Planning Services Sign Permit Review Form

Date of Submittal	Application Number	Applicant	Landowner
8/9/2022	SIGN2208-0003	Clayton Constructors, Inc. DBA Post Nursery	Smith Douglas Homes

Contact Person	Contact Number	Sign Location	PIN Number
Justin Hooks	919-554-4002	20' by 30' sign easement	0539-71-6223.000

SMITH DOUGLAS HOMES
DUNCAN'S CROSSING
LANDSCAPE DETAILS

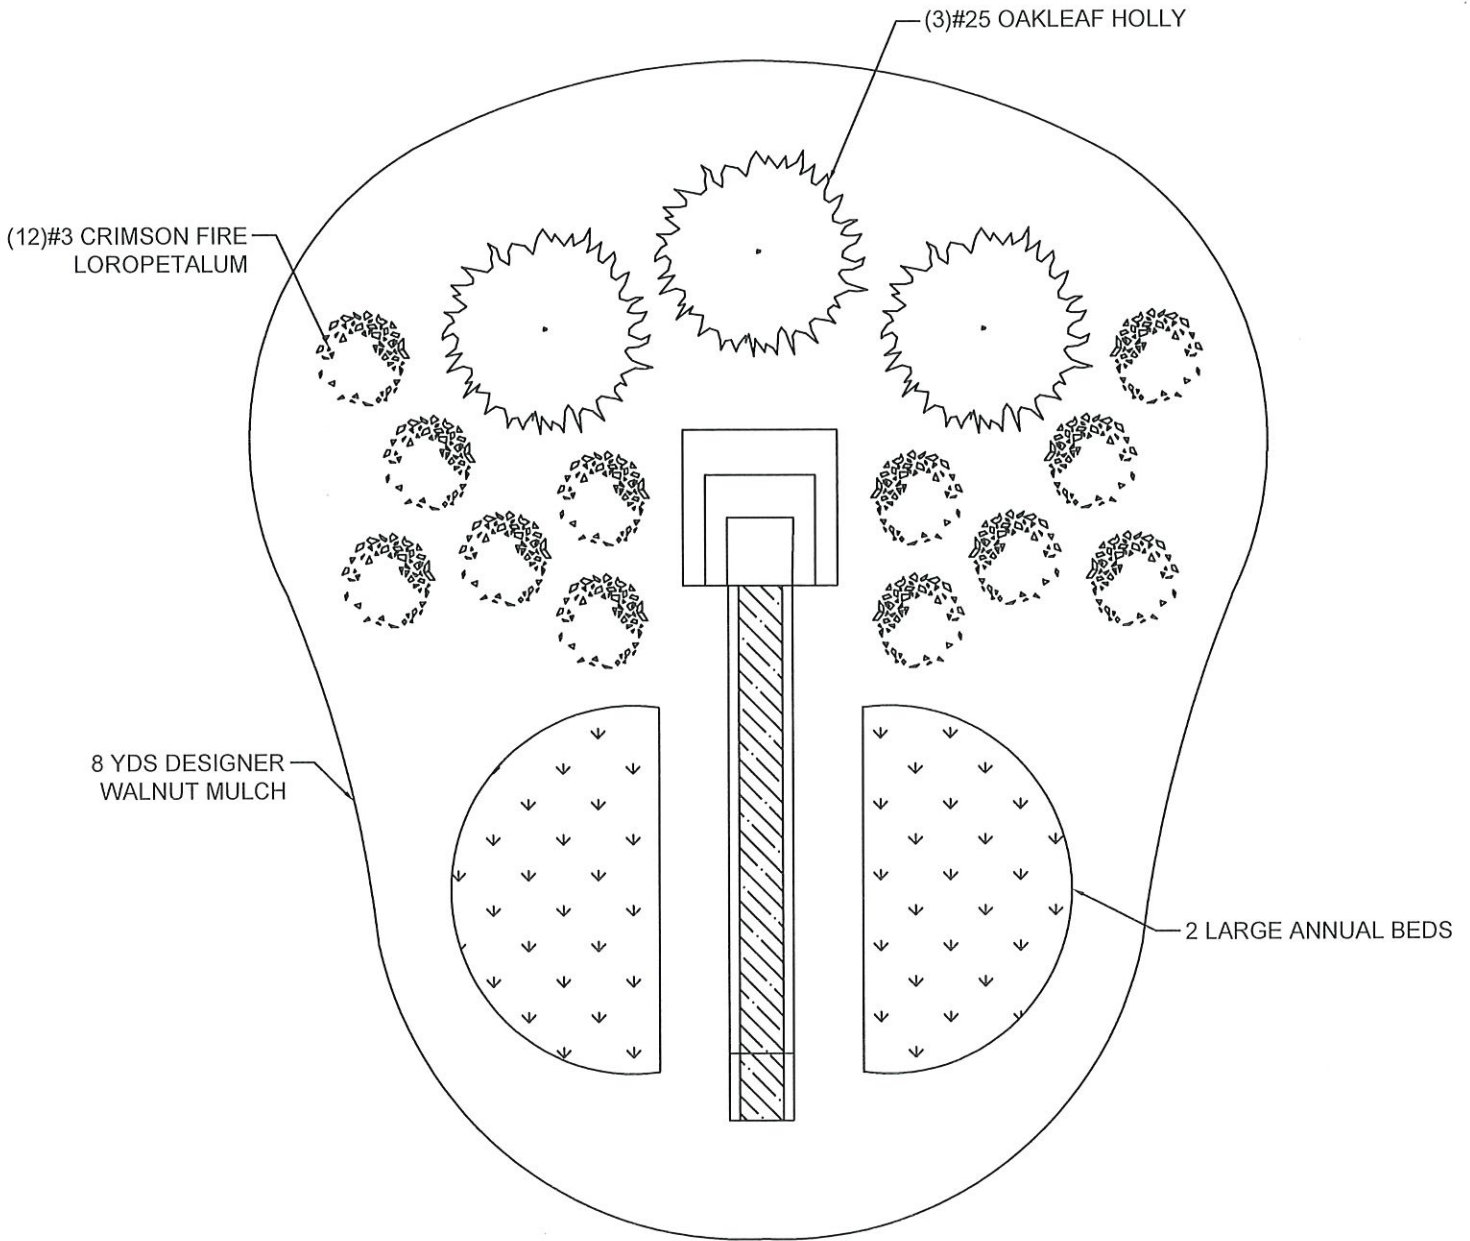
Comments	- Please provide the setback from the sign to the side property line and ROW. Sign must be 20' from side property line and ROW.
----------	---
